Norwich to Tilbury

Document: 9.2 Notification of proposed change to DCO application -
Change Request 2 (Little Bromley)

Planning Inspectorate Reference: EN020027

Little Bromley: Change to the EACN access (Change Request 2)

THE NATIONAL GRID (NORWICH TO TILBURY) ORDER
 PROPOSED CHANGE ORDER LIMIT PLANS - CHANGE REQUEST 2
 CURRENT PROPOSED PROJECT DESIGN ORDER LIMITS
 REGULATION 5(2)(o)
 SECTION C (SHEET A, TENDRING DISTRICT COUNCIL)

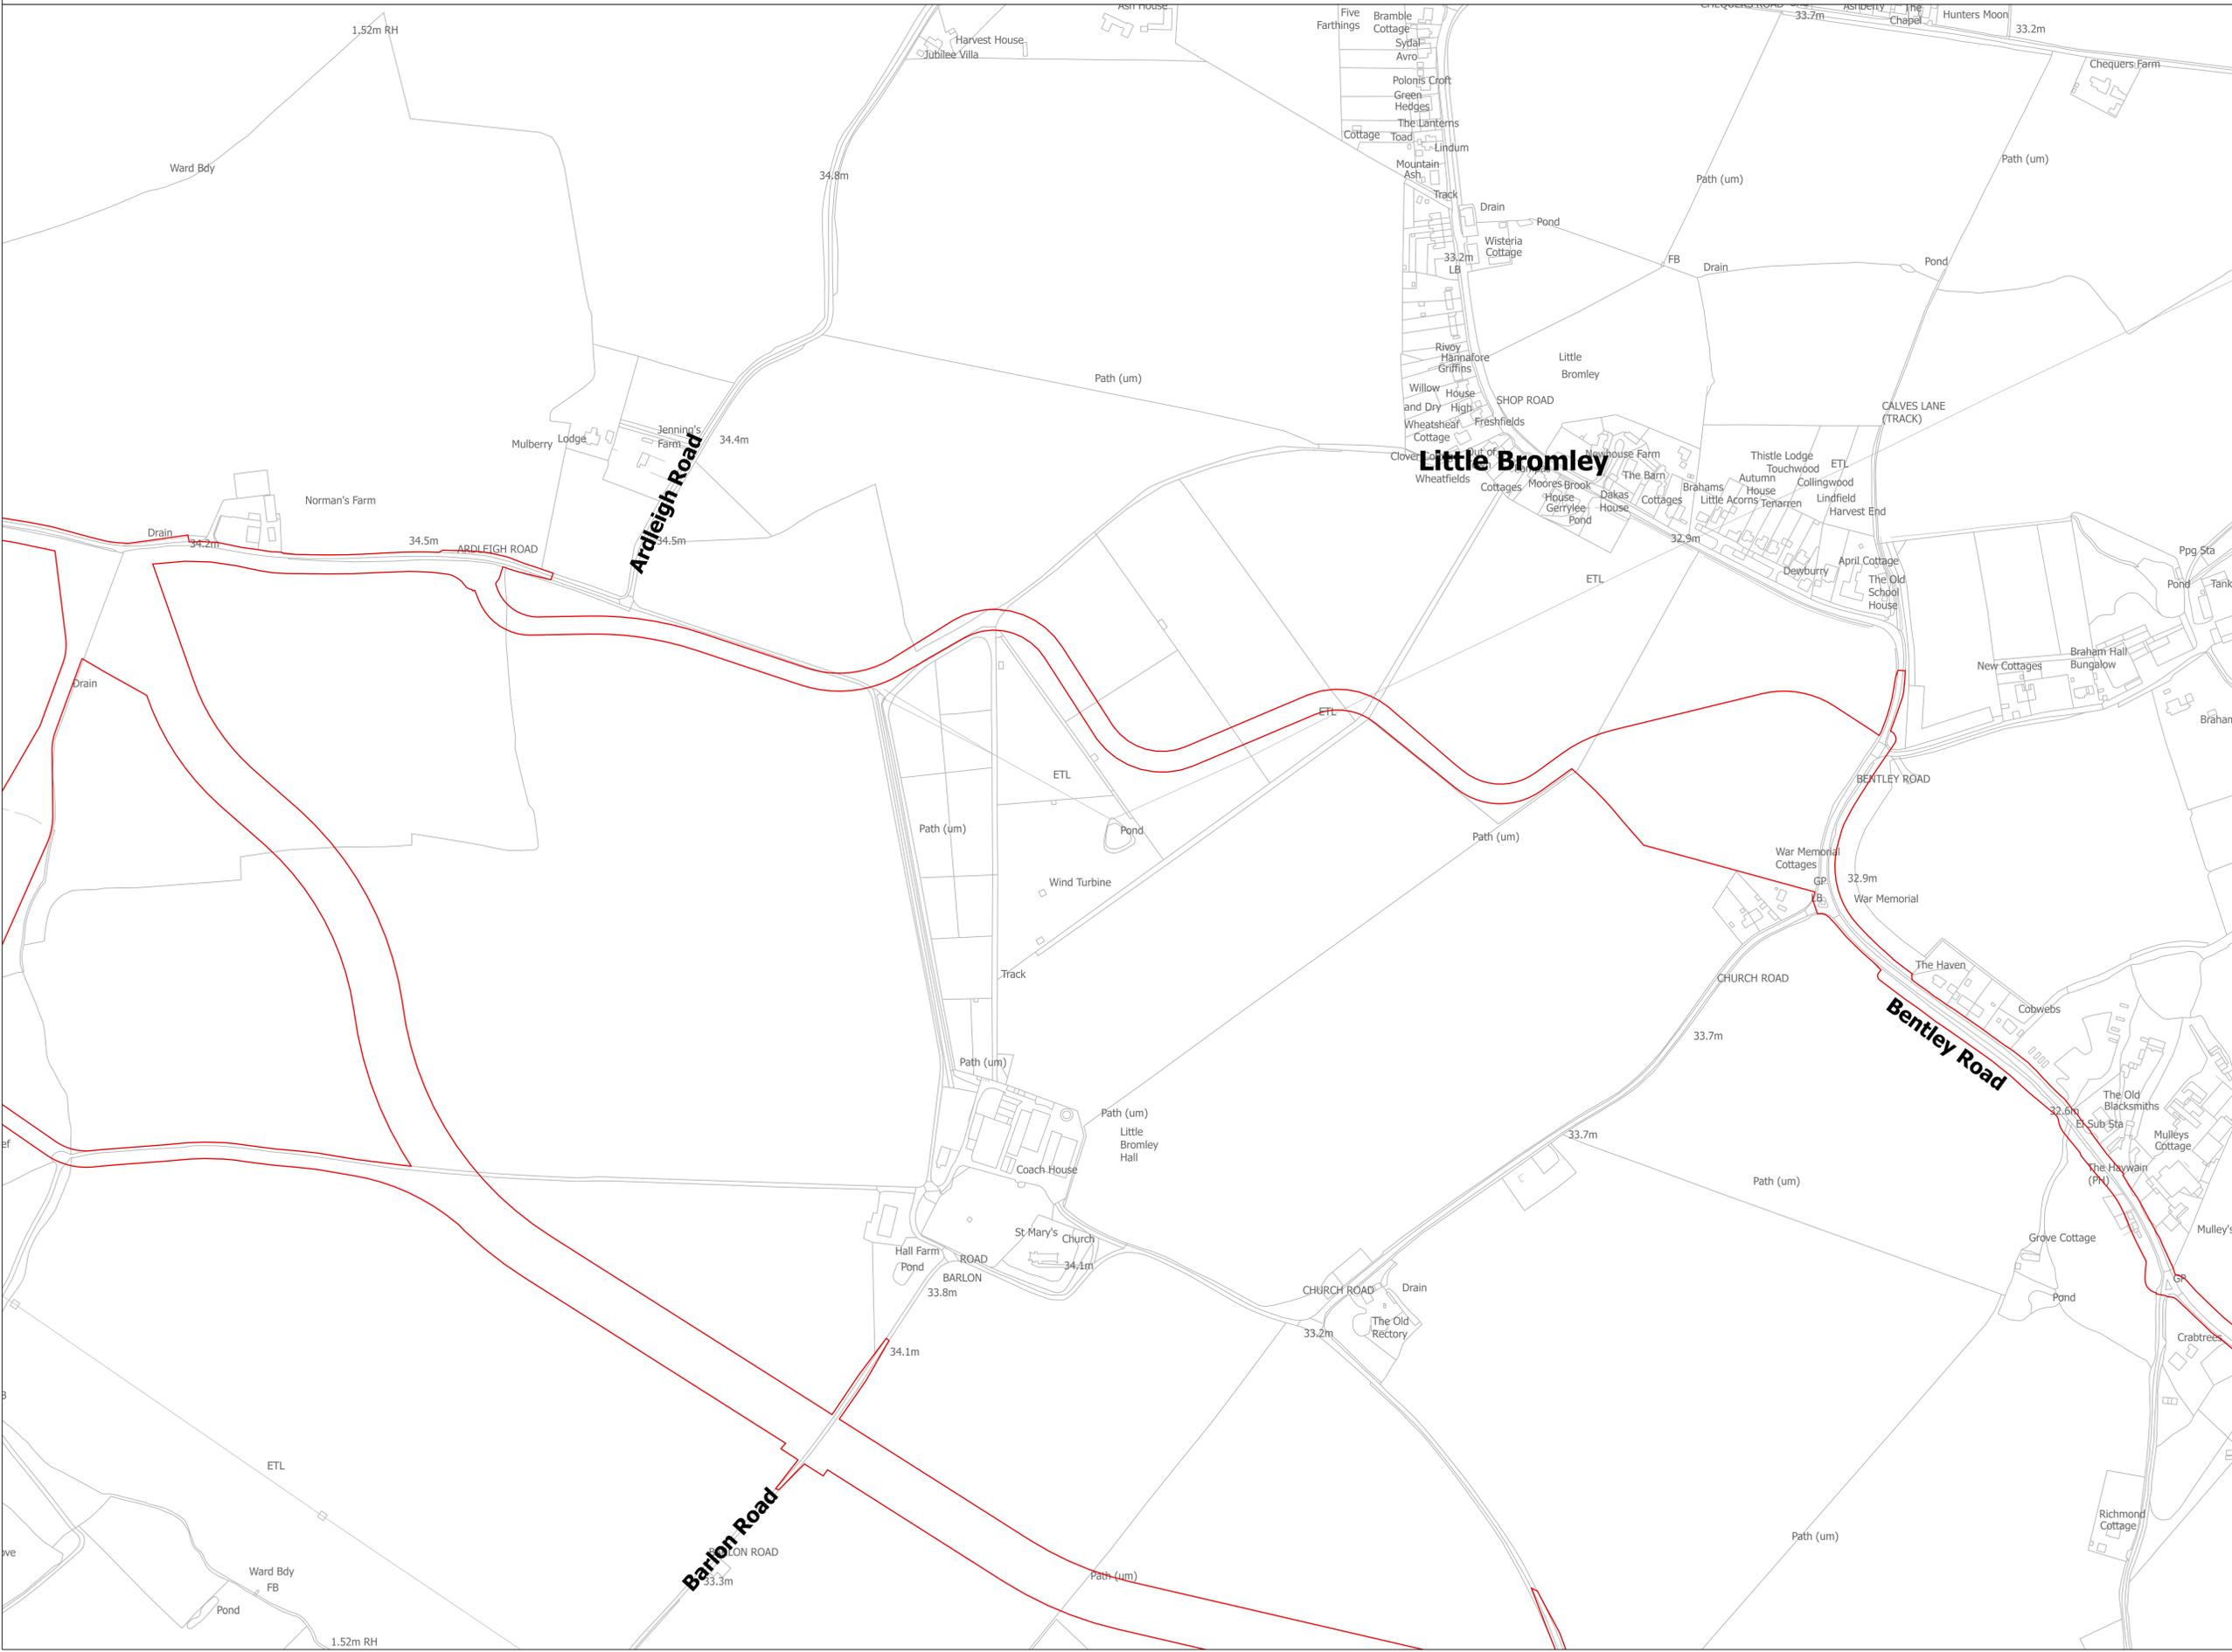
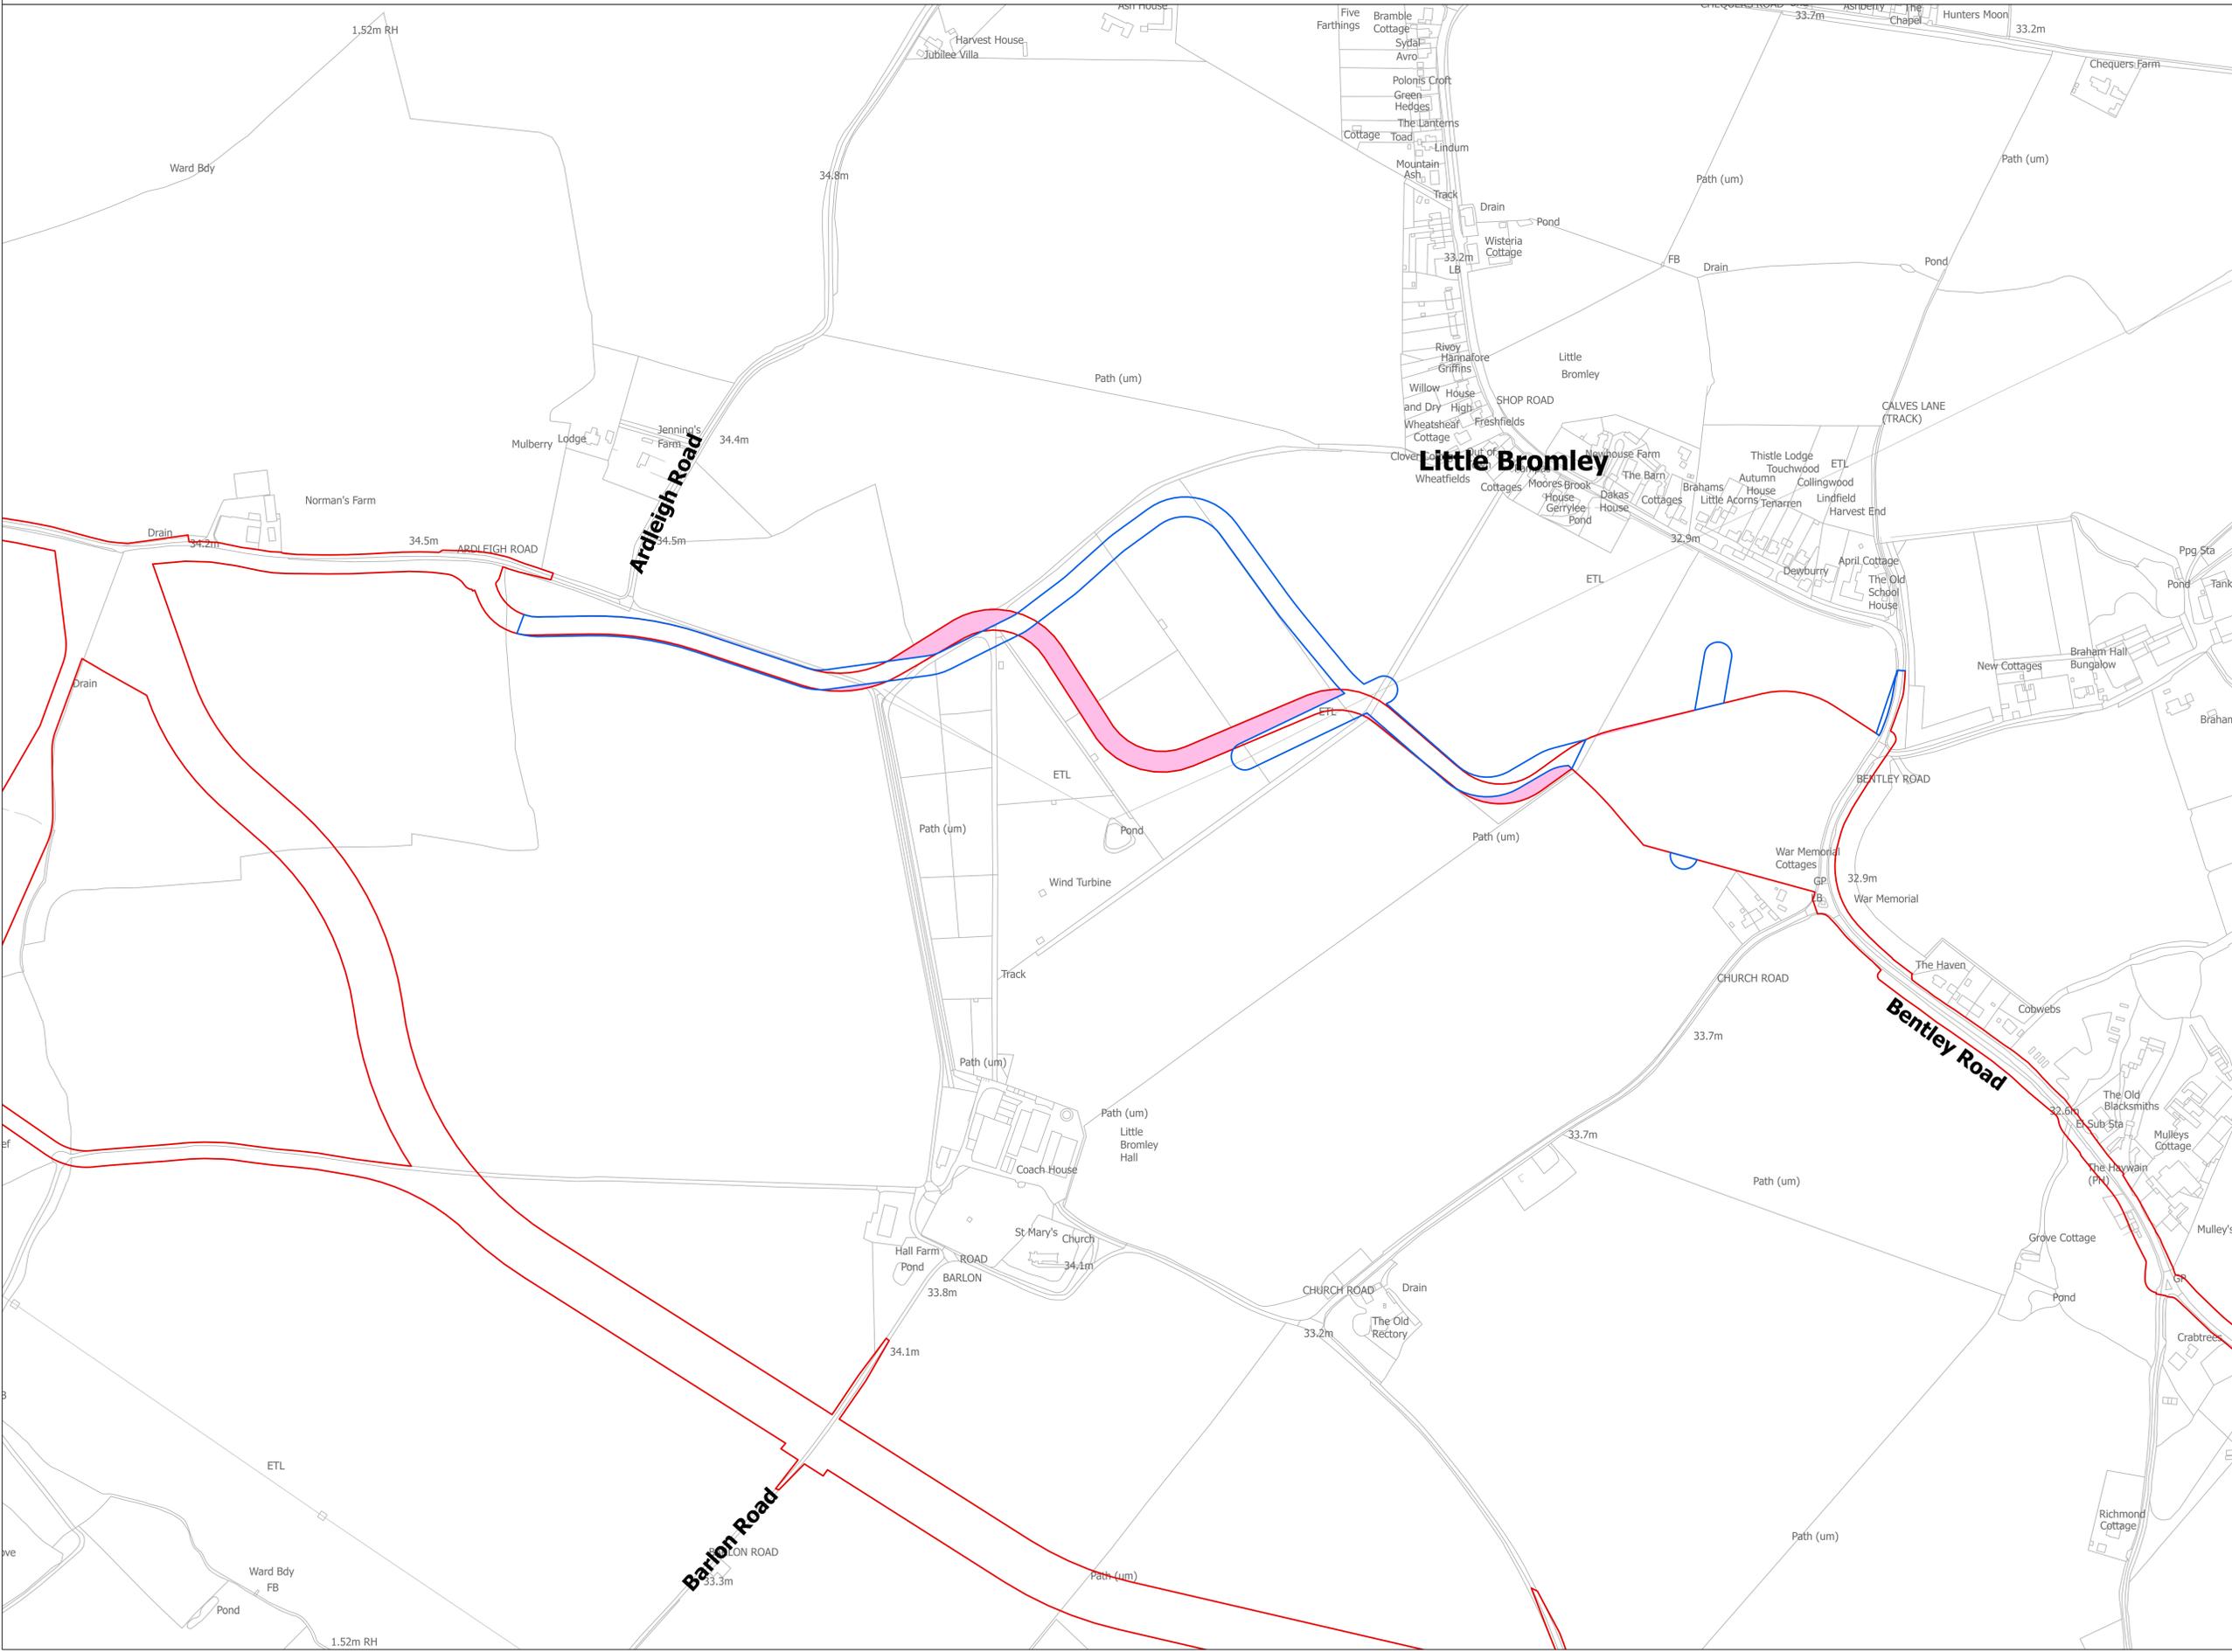
- 2.1.7 Change Request 2 would involve two modifications to the Proposed Route;
- Firstly, a section of the Proposed Route nearest to Bentley Road has been amended to provide a modified alignment for the permanent access relating to Abnormal Indivisible Loads ("AIL") during the operational phase of the Project. The need for a permanent AIL route is to ensure supply standards for the connection are met in the future (by allowing replacement of any component at short notice).

- Secondly, to the northwest of the first modification, the Proposed Route, for both construction and operational vehicles, has been changed back to the alignment presented at statutory consultation between 10 April to 26 July 2024.

- 2.1.8 In both cases, the modifications respond to feedback from, and ongoing detailed discussions with, affected landowners in order to secure an operational access arrangement that meets the Project need whilst also facilitating ongoing land management. The first modification (concerning the AIL arrangement) is intended to minimise the effects of the Project on future arable cropping, whilst the second modification ensures that the Proposed Route more closely follows field boundaries.

- 2.1.9 Additionally, precautionary amendments to existing wood pole supported infrastructure will be accommodated as part of Change Request 2.
- 2.1.10 The Applicant considers that the proposed change will not result in any new or different likely significant environmental effects to those reported in the **Environmental Statement (ES) (APP-123 to APP-287)**. This will be confirmed in an Environmental Statement Addendum Report that will be submitted with the Proposed Change Application 2. The proposed change is not considered to affect compliance of the Project with planning policies detailed in the **Planning Statement (APP-085)** and **Policy Compliance Document (APP-086)**.

- 2.1.11 The arrangement has been subject to extensive discussion and consideration of alternatives with relevant landowners.
- 2.1.12 The Order Limits are to be amended as a consequence of the proposed change, with powers of compulsory acquisition and temporary possession to be sought by the Applicant over the additional land intended to be brought within the Order limits. Accordingly, the CA Regulations are engaged.
- 2.1.13 The Applicant has therefore sought the consent of those landowners to the inclusion within the draft DCO (if granted) of compulsory acquisition powers for new land and rights in respect of the land affected by the proposed change. However, it has not been possible to obtain such consent in advance of issuing this change notification.
- 2.1.14 The proposed change to the Order Limits is shown on the figures in **Appendix A**.
